**Objection to planning permission Ref. 3/2025/0758
At land off Whalley Road, Hurst Green**

“Change of use of agricultural land to four no. 1 bedroom holidays lodges, relocation of site access, improvements to public footpath and associated landscaping”

Rev.	Date
A	16.03.26

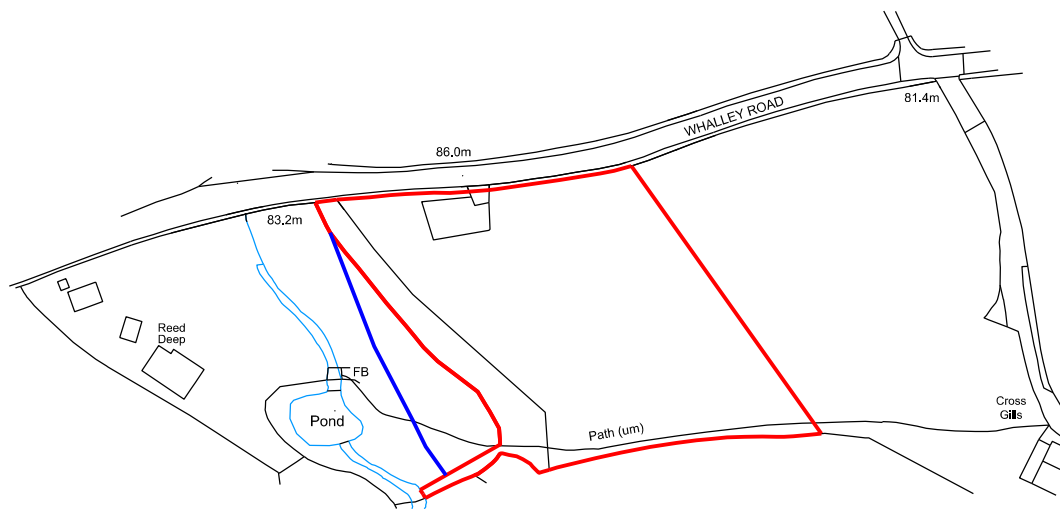
Whilst notice under Certificate B has now been served [REDACTED], the site location plan and red line boundary continues to fail to include all land necessary to carry out the proposed development. In particular, the red line boundary fails to [REDACTED] required to construct a surface water drain to discharge surface water to the watercourse in our [REDACTED]. This is particularly important given it is the only practical, deliverable and viable means by which surface water can be drained from the site. Furthermore, the site location plan fails to meet the requirement to including visibility splays within the red edge. This is important as we consider that part of the visibility splay fall within [REDACTED] notwithstanding the applicant’s assertion that it doesn’t.

The LPA’s attention is also drawn to the fact that the northwest corner of the application site where it adjoins Whalley Road and the PROW is not in the applicant’s ownership, but rather [REDACTED] [REDACTED] (see enclosed title plan). [REDACTED] does not consent to the inclusion of this within the site. It should therefore be removed from the application site boundary. In addition, part of this land is within the visibility splay of the site access. As such, the applicant is unable to deliver the required visibility splay to the west entirely in land in his control.

DRAWING REFERENCE: 2025-040-01

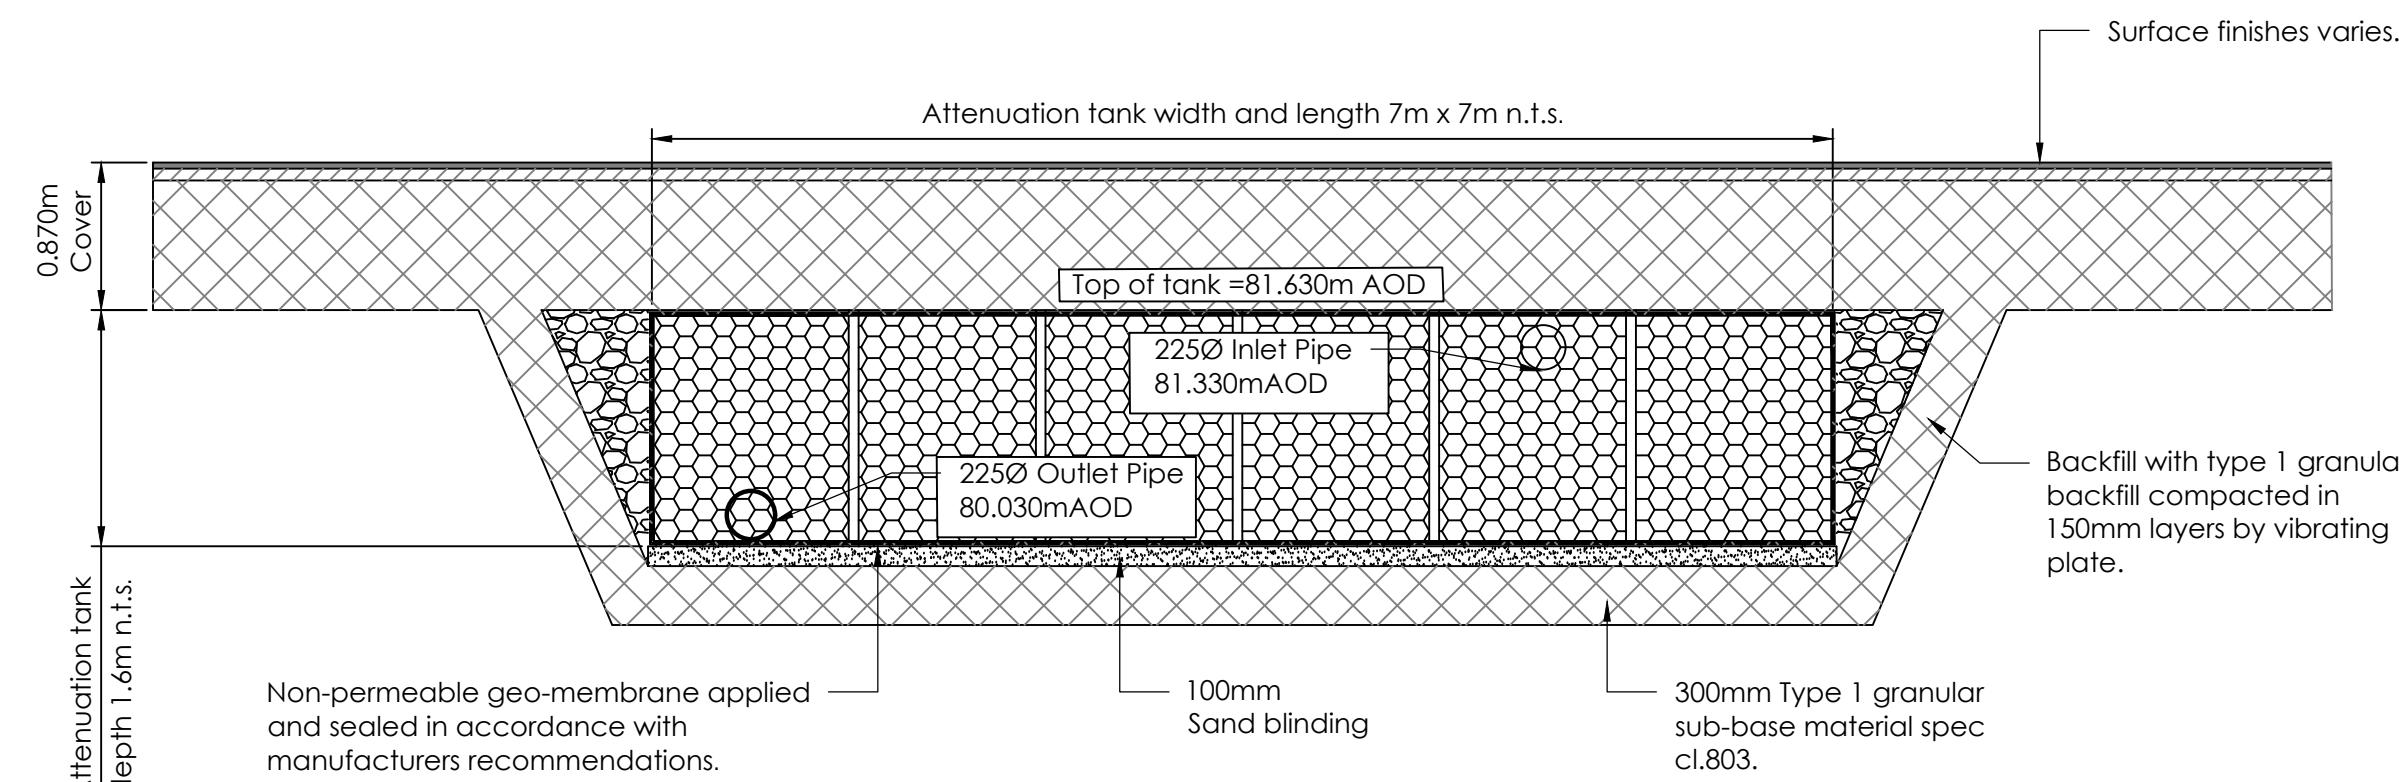
Response - The applicant is unable to demonstrate a deliverable and viable means of draining surface water from the site. The application currently purposes a connection to the watercourse [REDACTED] which requires a drain across it. [REDACTED] have advised the LPA on numerous occasions that this is not acceptable to them and that consent will not be given to such a drain. As a result, the applicant should be requested to demonstrate how they propose to drain surface water from the site. They should also be required to evidence that the proposed solution is deliverable and viable.

It remains the case that the scheme is predicated on a new surface water drain being provided across [REDACTED] which they do not consent to and will not consent to. As a result, the applicant has failed to demonstrate that there is a suitable, feasible, deliverable and viable means of draining surface water from the site. This is a prerequisite of Policy DME6 and given it cannot be complied with planning permission should be reused

Existing Site Plan
Scale 1:500

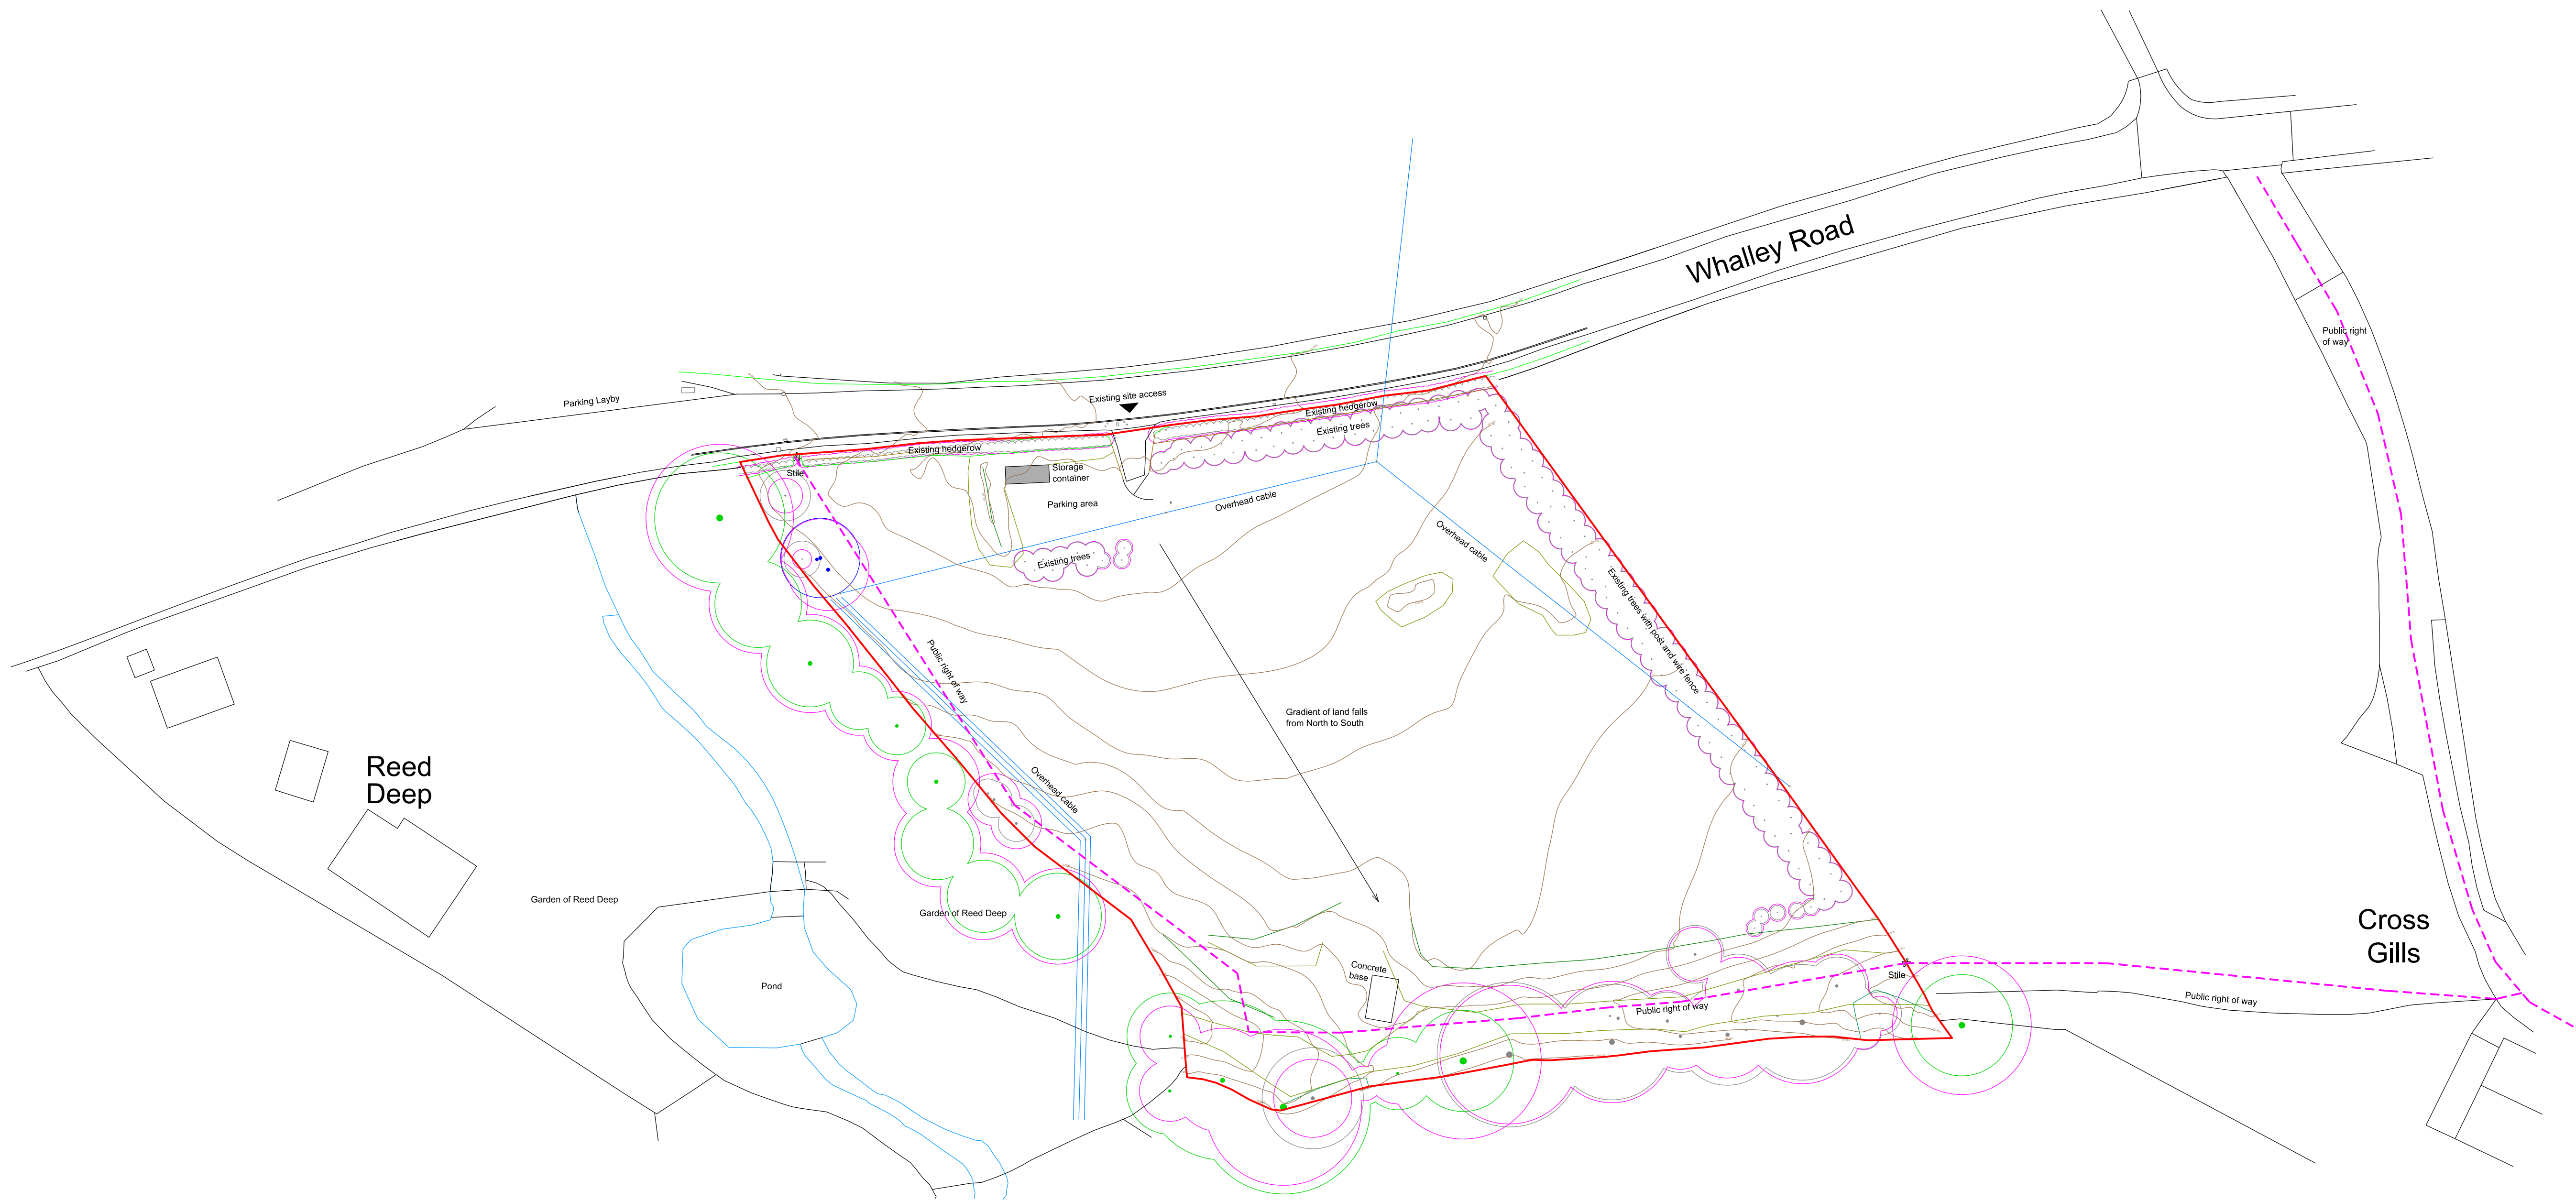
- *Site Location Plan* – as set out above this does not satisfy national validation requirements.
- *Existing Site Layout Plan* – this contains no topographical information or site levels, but only vague contour lines. As such, it is not possible for the LPA to fully understand existing site levels to then be able to compare these to proposed site levels and then understand the proposed land regrading and level changes and thus the visual and landscape impact of the scheme.

Proposed Section A - A
Scale 1:200

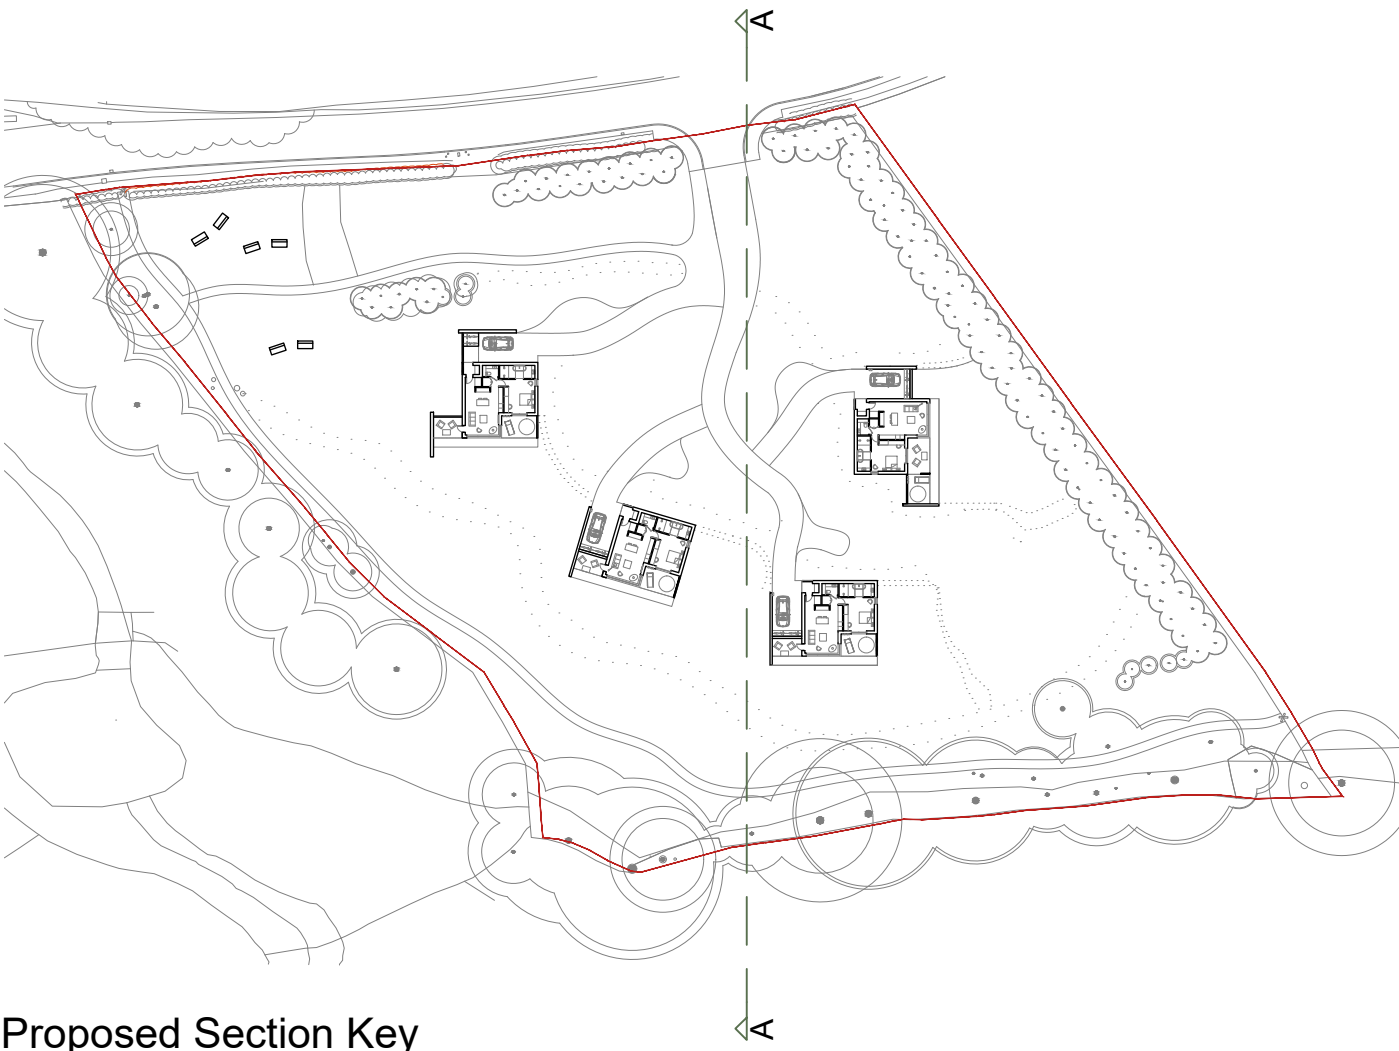
- *Site sections* – the submitted site section is entirely meaningless. Not only does it not contain any site levels or finished floor levels, but in the absence of existing site sections to compare it to it is impossible to understand how the land within the site will be regraded to accommodate the proposed development.
